re: Geotechnical Review – Grading Plan Review

Proposed Residential Development 3317 Navan Road - Ottawa, Ontario

date: February 27, 2024 file: PG6582-MEMO.04

GEOTECHNICAL RECOMMENDATIONS - INSULATION FOR SHALLOW SEWERS

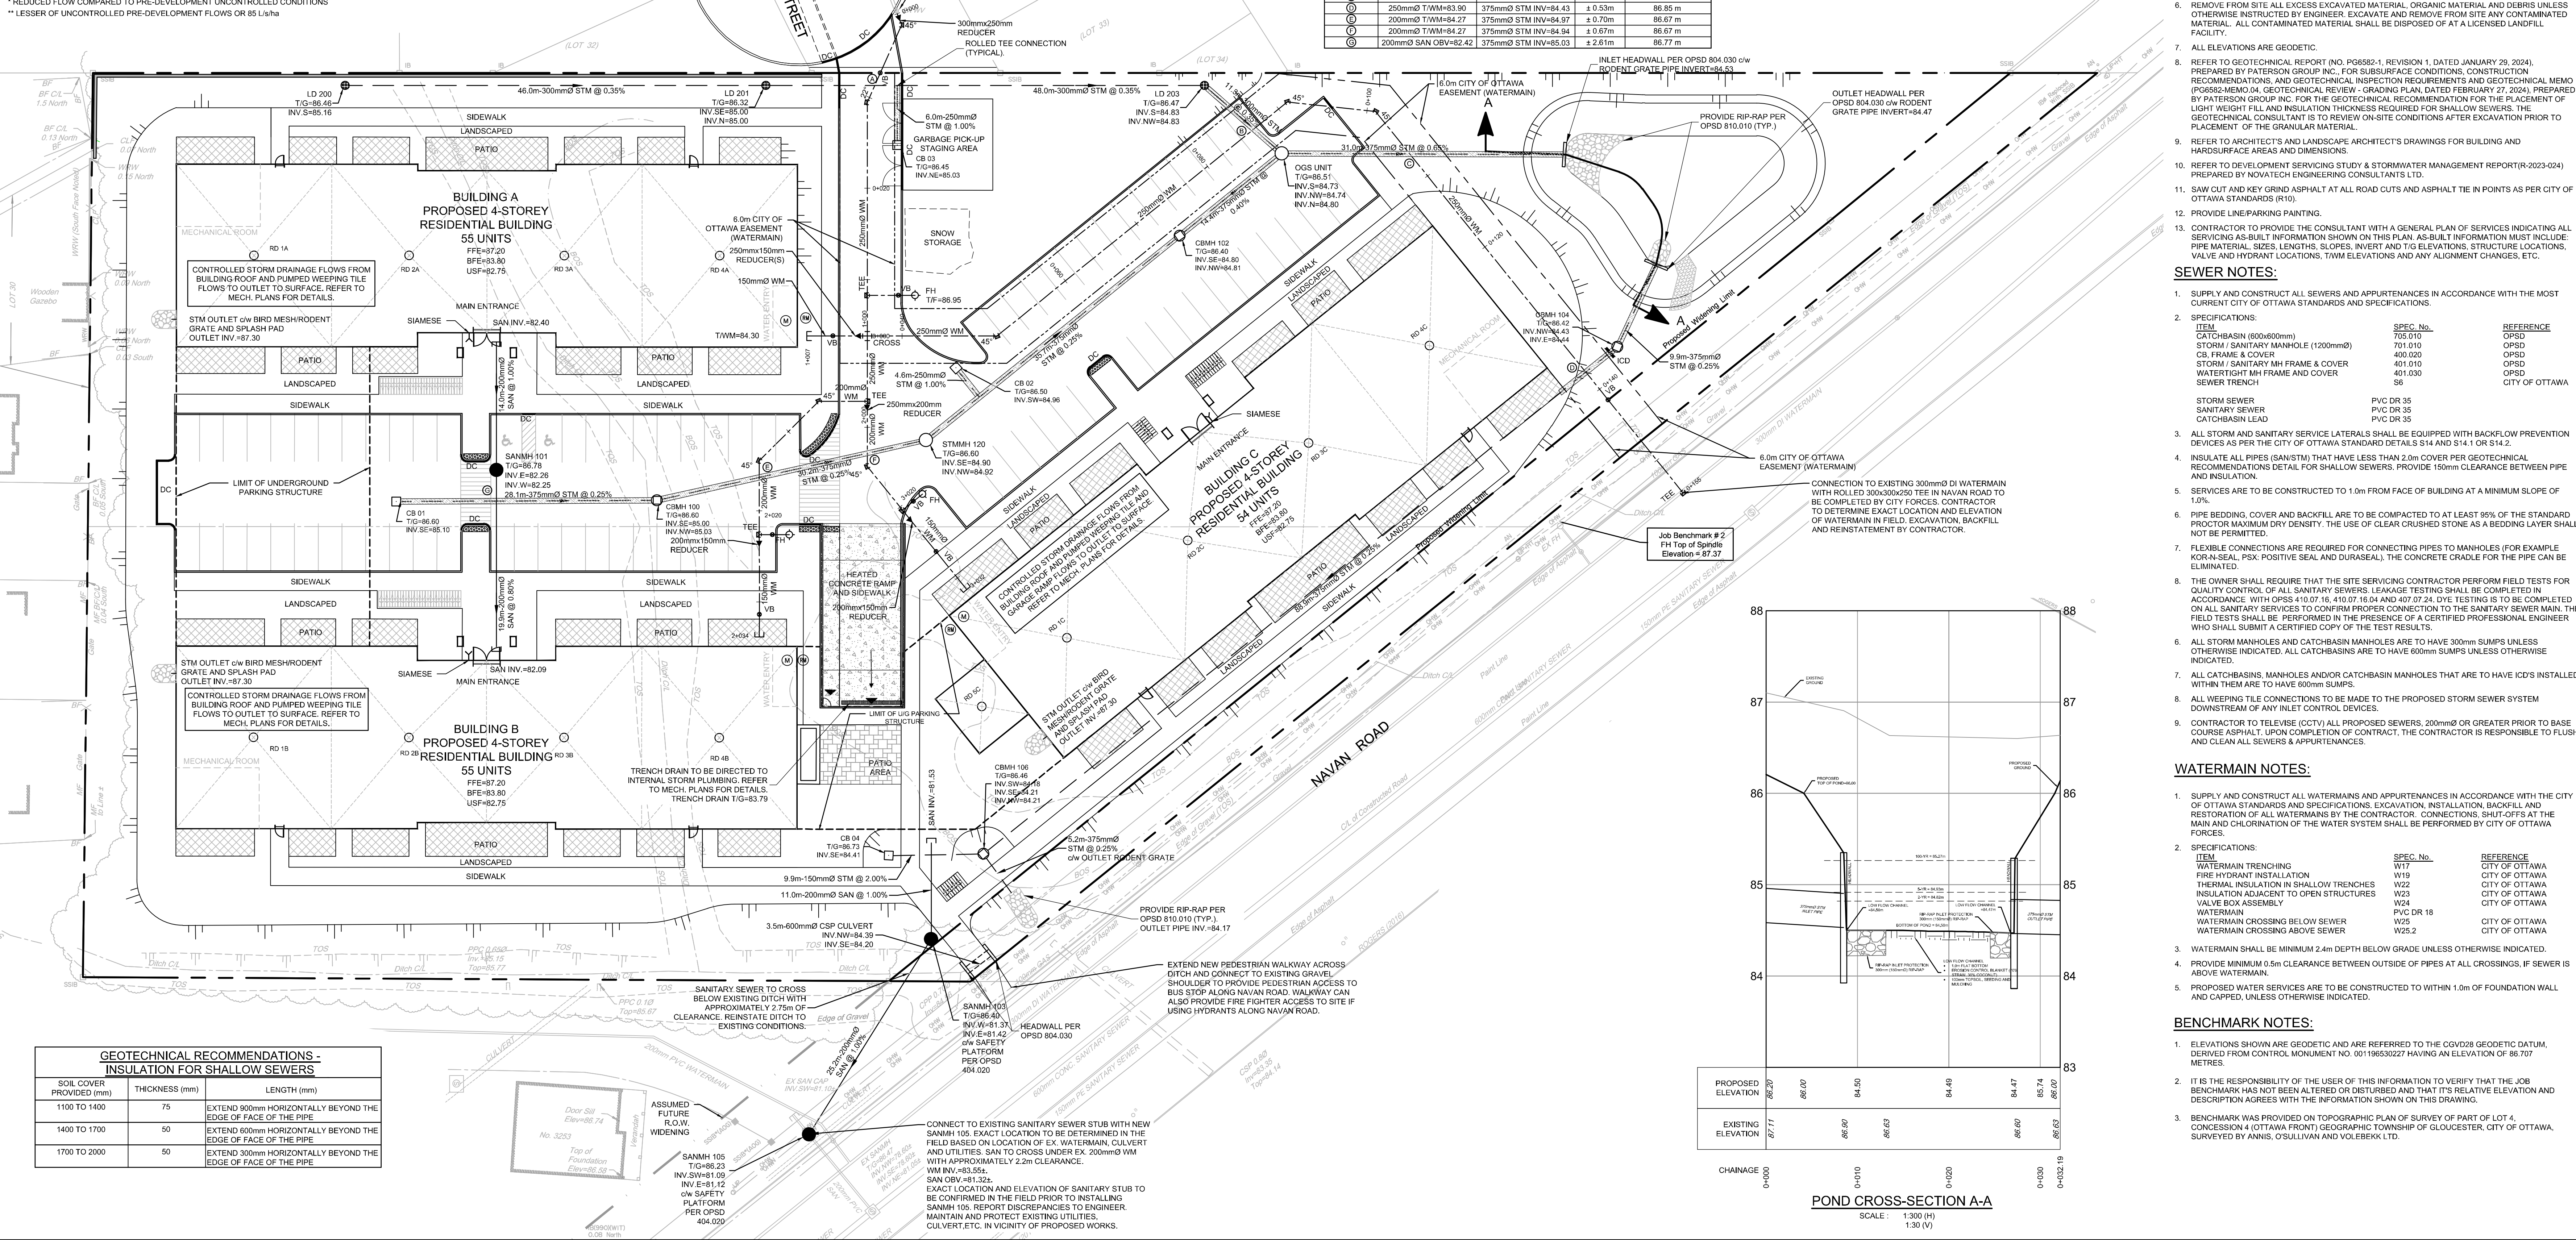
Based on our review of the abovementioned site servicing plan, it was observed that some portions of the proposed storm service lines will have less than 2 m of soil cover. Where

insufficient soil cover (i.e.- less than 2.0 m) is available, the following frost protection criteria outlined in Table 1 below.

Soil Cover Provided D (mm)	Insulation Dimensions (mm)	
	Thickness (mm)	Length (mm)
1,100 to 1,400	75	Extend 900 mm horizontally beyond the edge face of the pipe
1,400 to 1,700	50	Extend 600 mm horizontally beyond the edge face of the pipe
1,700 to 2,000	50	Extend 300 mm horizontally beyond the edge face of the pipe

No.	REVISION	DATE	BY
4.	REVISED PER GEOTECHNICAL COMMENTS	FEB 27/24	FST
3.	REVISED PER CITY COMMENTS	FEB 14/24	FST
2.	REVISED PER CITY COMMENTS	NOV 13/23	FST
1.	ISSUED FOR SITE PLAN CONTROL APPROVAL	JUNE 02/23	FST

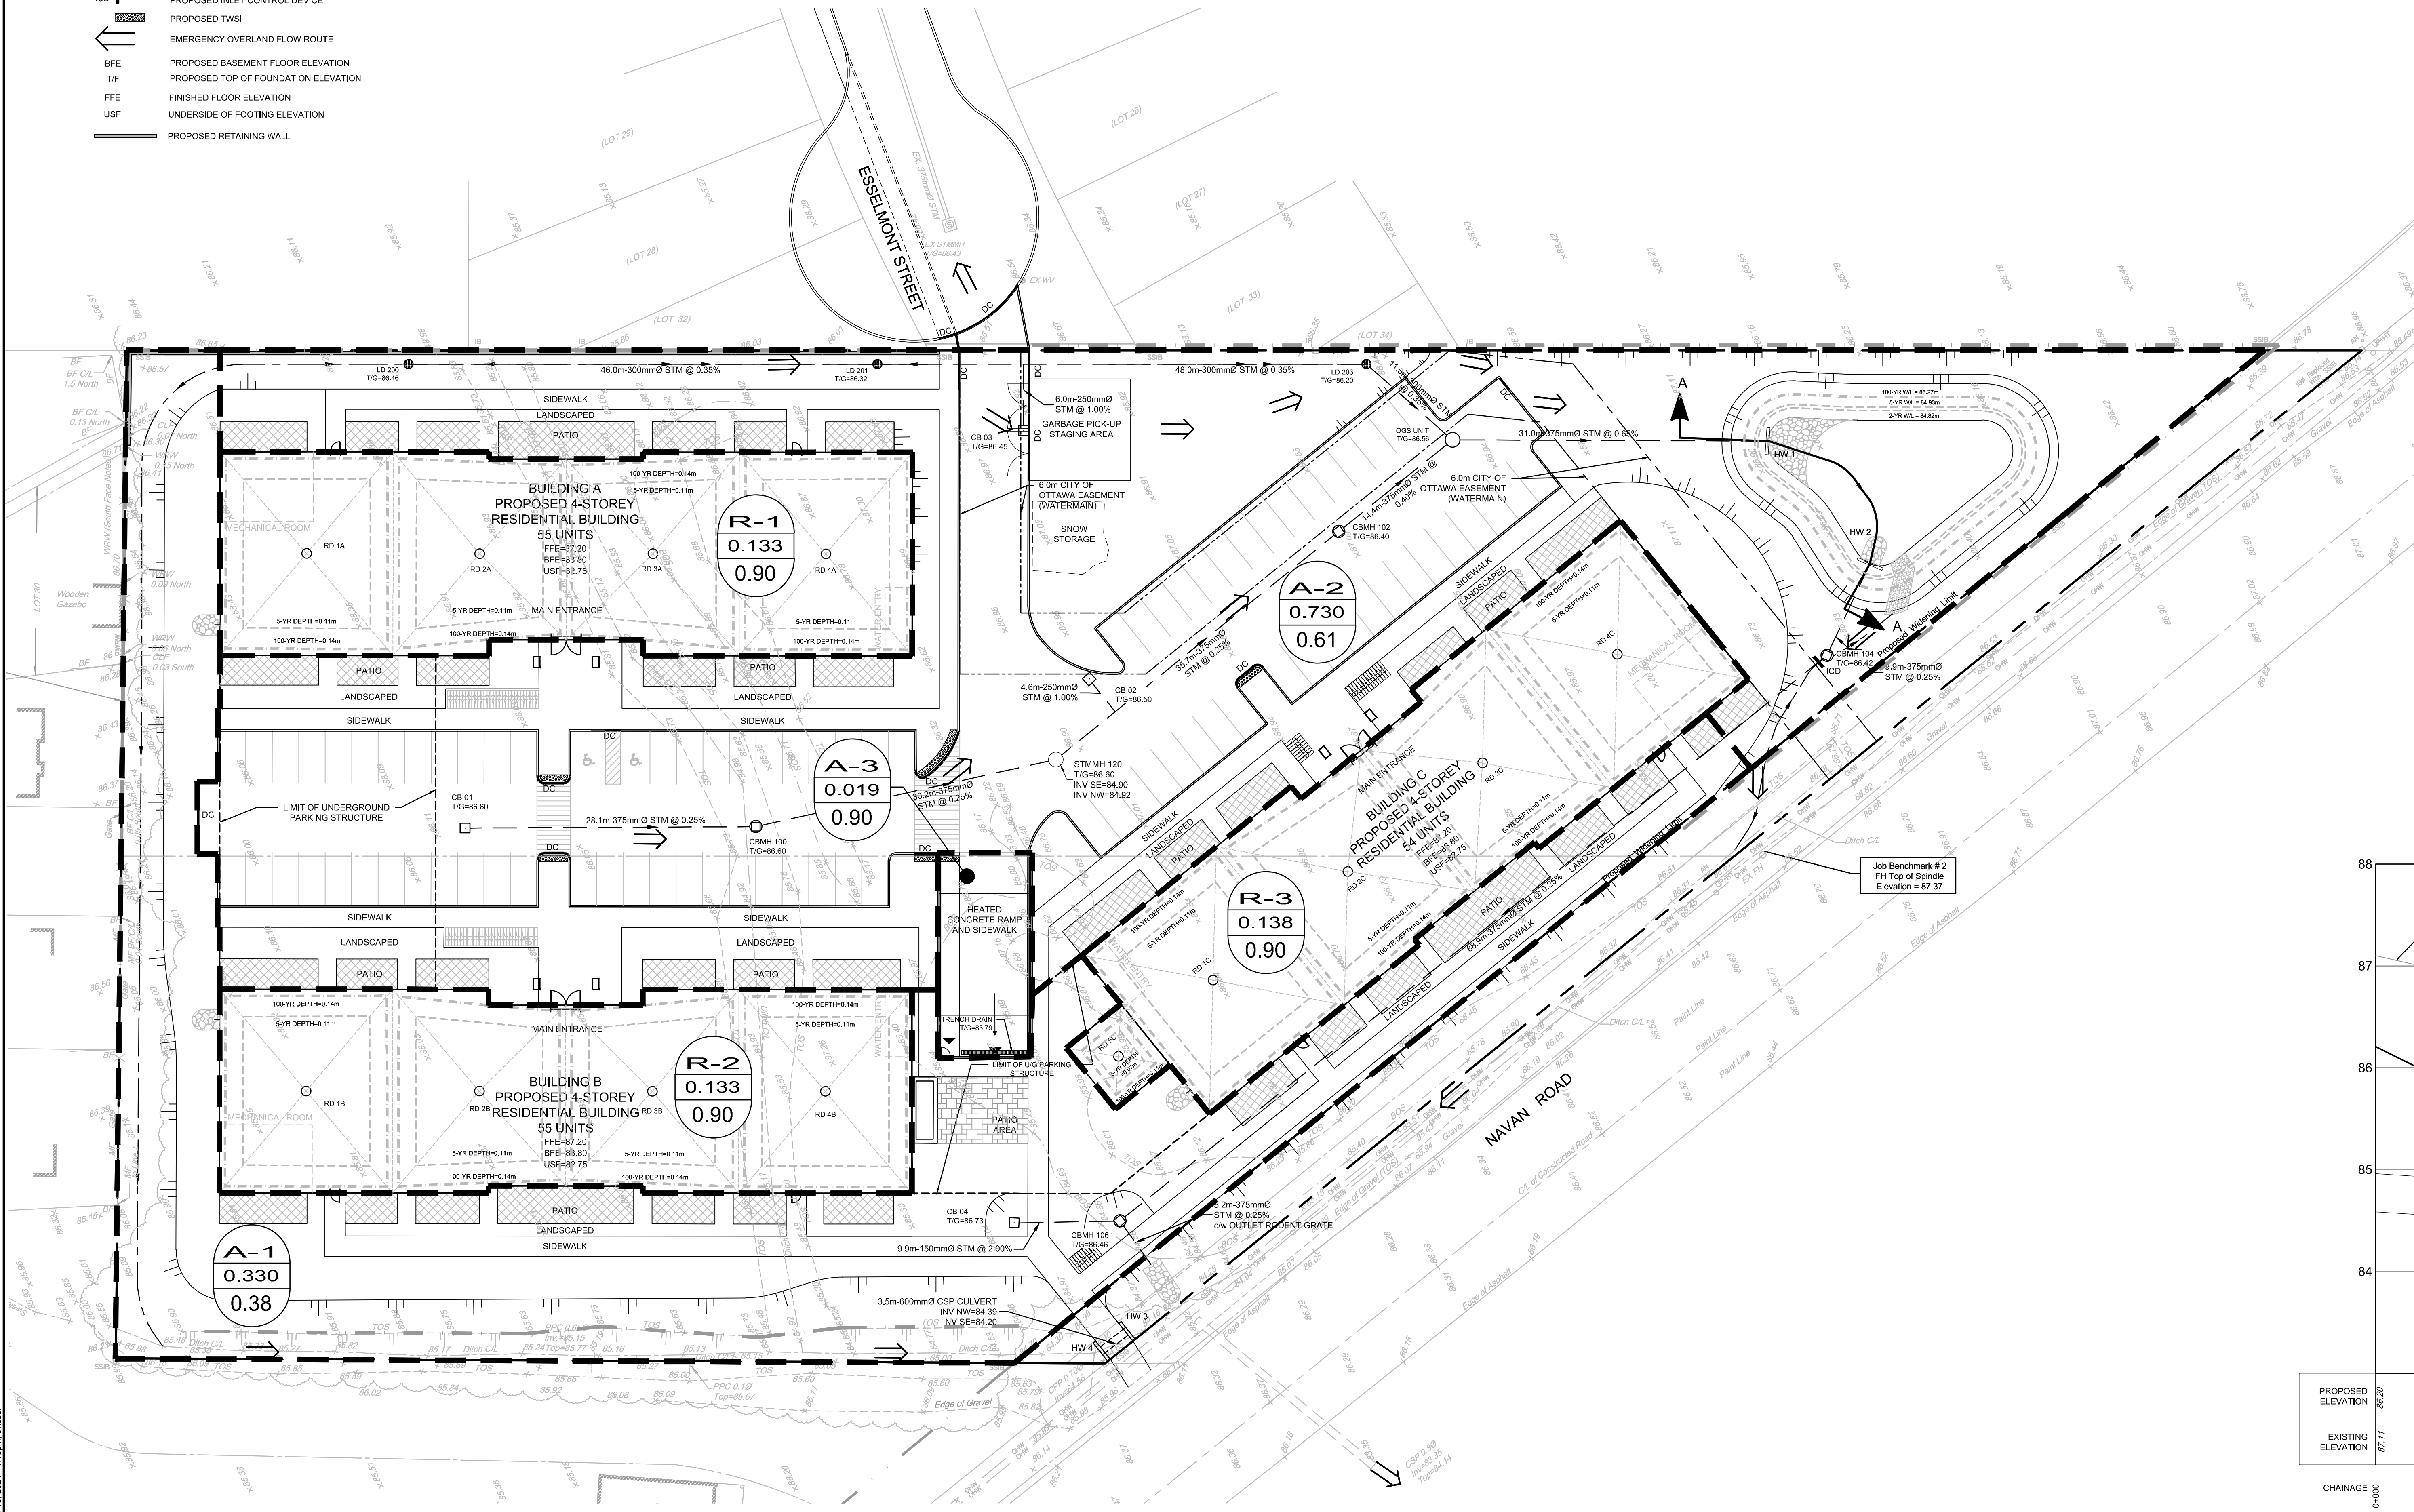
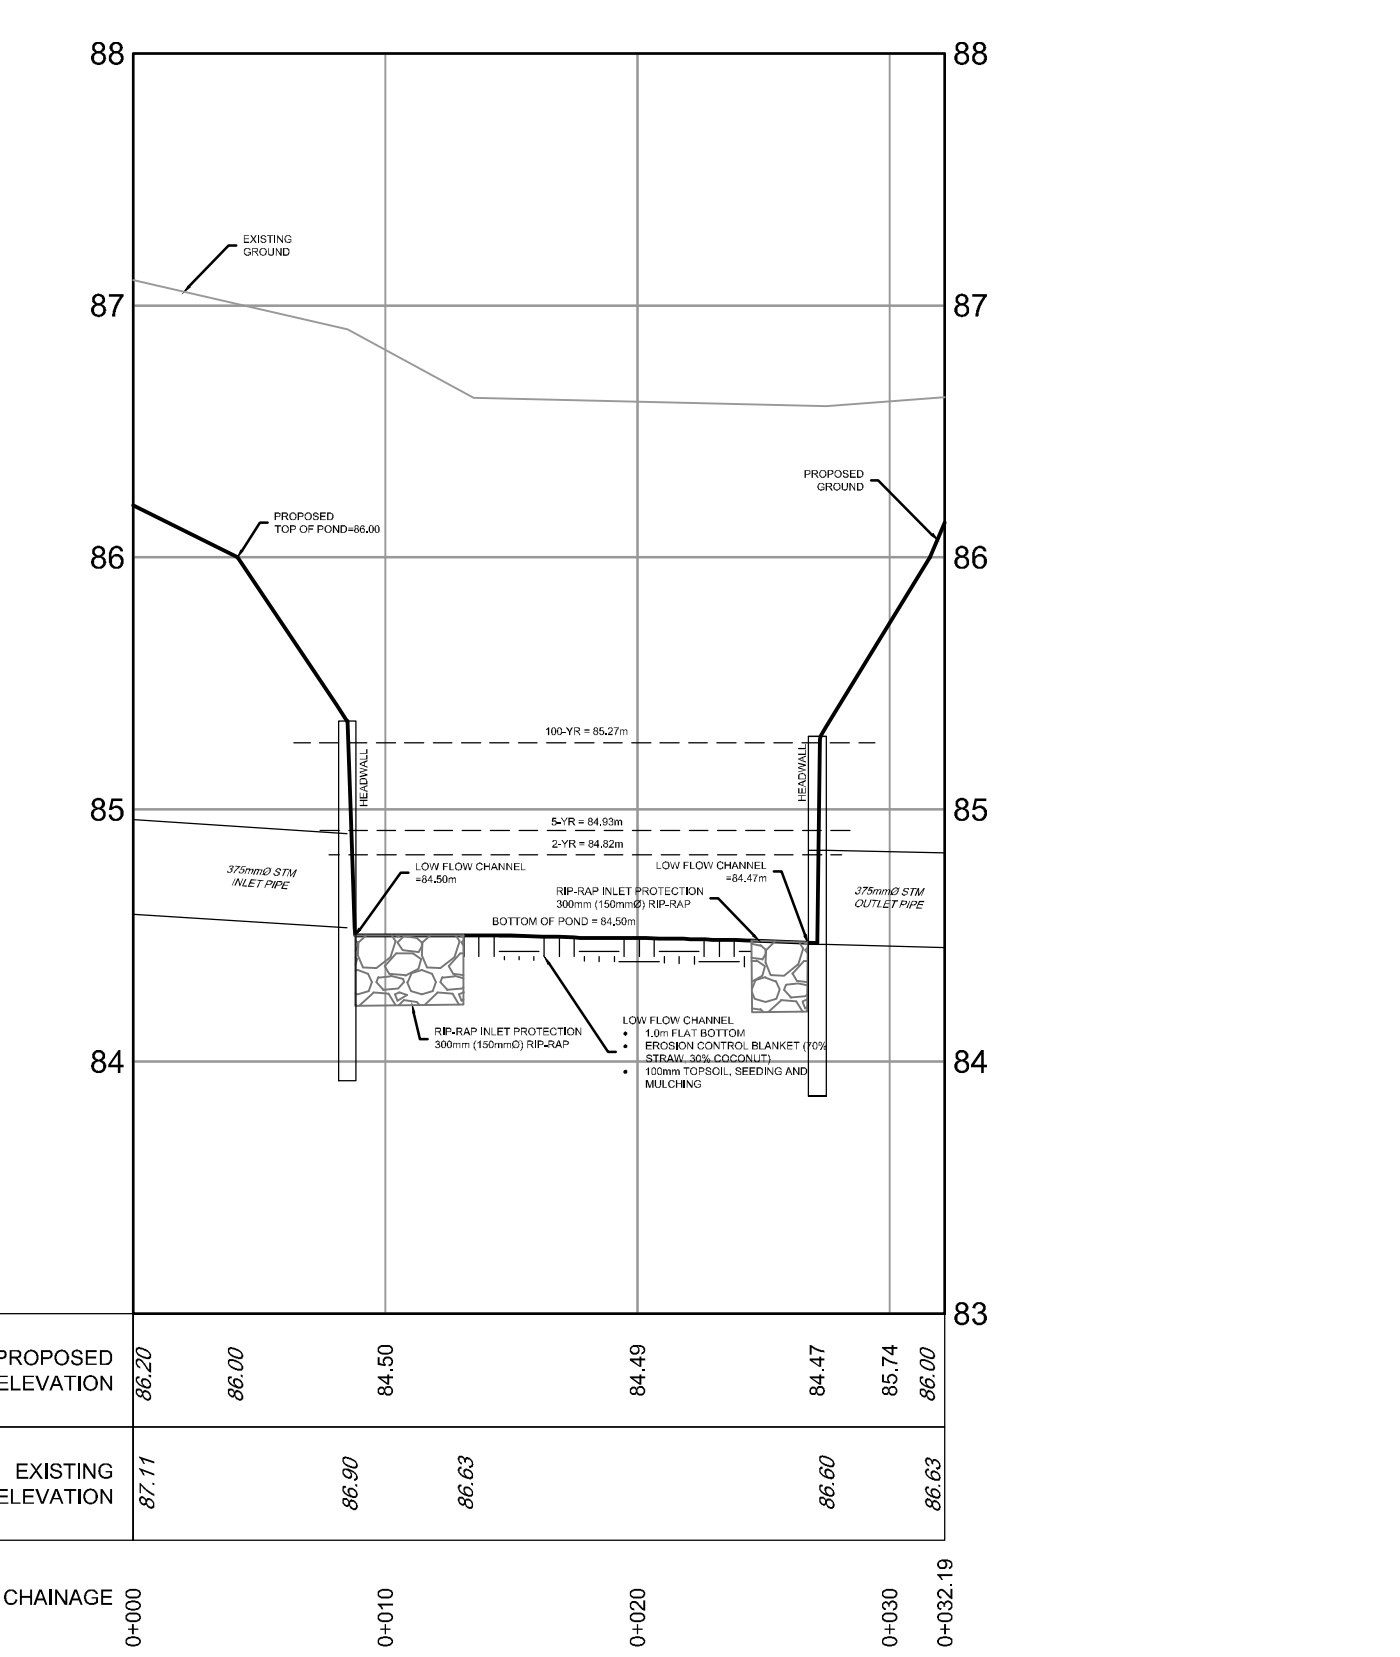
Based on our review of the above noted drawing, the proposed grading for the residential unit exceeds the permissible grade raise recommendations. Our lightweight fill recommendations are presented in the grading plan attached to the end of this report.

The LWF material should consists of EPS 15 under pavement and other parking structures and EPS 12 under soft landscaped areas. The LWF should be placed against the foundation wall, above the footing and a minimum of 600 mm below the finish surface. The LWF EPS blocks should extend a minimum of 2.4 m from the foundation wall with the thicknesses recommended in the attached marked up grading plan.

Based on our review of the grading plan, it was found that the north access lane and parking areas have exceeded the permissible grade raise. To protect proposed services and retaining wall LFW is recommended under the pavement structure.

Where LWF is required in the parking and access lanes, as indicated in attached mark ups, minimum 100 mm of HI-60 rigid insulation should be placed on the level native soil surface prior to the installation of the granular pavement base and subbase. The rigid insulation should be covered with a non-woven geotextile such as Terrafix 270 R.
